CITY OF ALBUQUERQUE

May 25, 2022

**Re: Champion Xpress
5101 Lomas Blvd NE
Traffic Circulation Layout
Architect's Stamp 05-11-0222 (J17-D010)**

DATE 5/11/2022	SHEET G3A
SCALE:

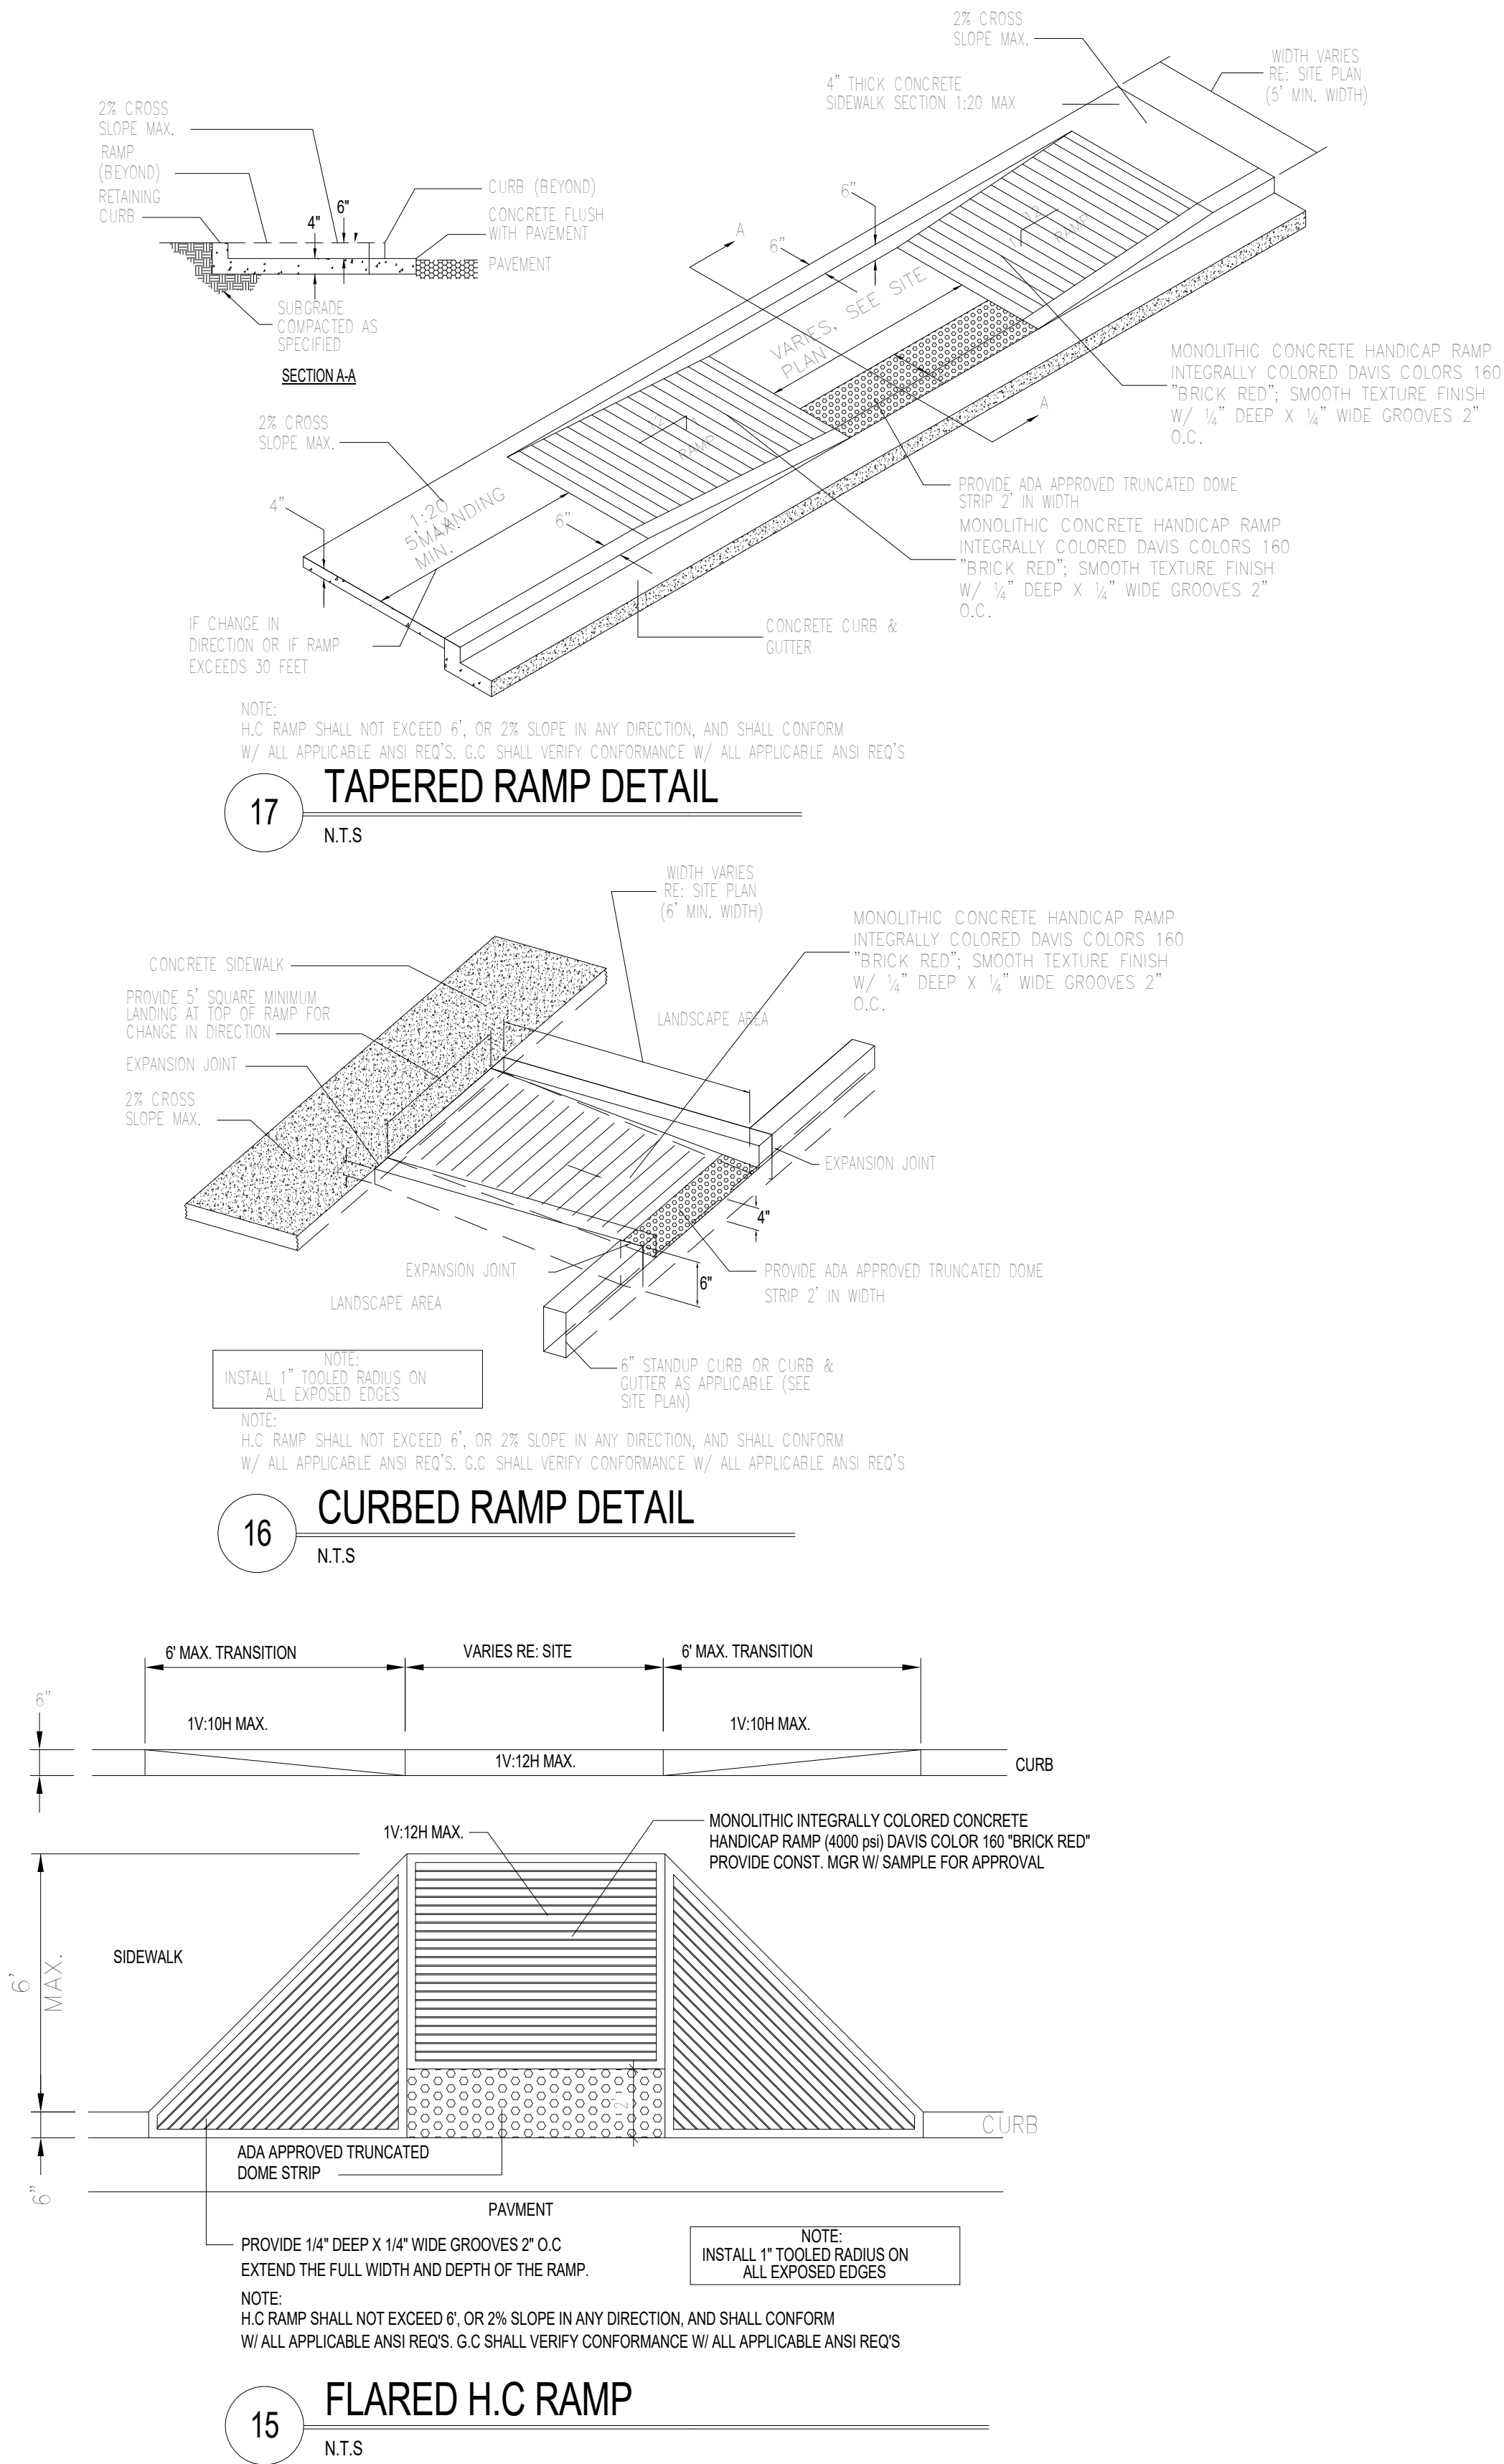
1. Does the car wash provide restroom facilities to public? If so, then an accessible access should be provided from the ADA parking stall aisle.
2. **Lomas/Manzano corner ramp:** It appears that the ramp lip is not ADA accessible. Please address this concern.

3. The proposed sidewalk connection coming off Lomas needs to be dimensioned.
4. **Manzano Exit driveway Entrance:**
 - The northern segment of proposed ramp is encroaching into 622 Manzano landowner frontage. You will need permission from landowner to have this work accomplished within his frontage property.

- Add Keyed Note 6 (STOP sign).
5. **Keyed Note 5 (Manzano):** Need to be placed on both sides of exit driveway.
6. **Keyed Note 14:**
 - You will need to provide a segment of concrete sidewalk on Manzano frontage since asphalt is existing in place of concrete.

- Reference COA std dwg 2430 for concrete sidewalk work.
7. **Keyed Note 21:** Add the text curb & gutter to statement on curb cut closure.
8. **Proposed Refuse driveway (Manzano frontage):**

- Please provide a symbol for the proposed 6 ft valley gutter as shown on entrance driveway off Lomas.
 - Provide the frontage width of proposed driveway (not shown).

9. **ADA parking stall:** It appears that vehicle backing out might be a concern with queue storage lane. Explain is this a problem or not?

10. Motorcycle parking stall:

- Why don't you provide a parallel stall to avoid any traffic situations.
 - MC text will need a detail.
11. Refuse vehicle maneuvering shall be contained on-site. The refuse vehicle shall not back into the public right of way. **Please explain the strategy on backing into the street causing a traffic safety concern.**

12. Add a note stating "All broken or cracked sidewalk must be replaced with sidewalk and curb & gutter." **A build note must be provided referring to the appropriate City Standard drawing (2430 & 2415A)- this segment of note will need to be added to General Note 5.**
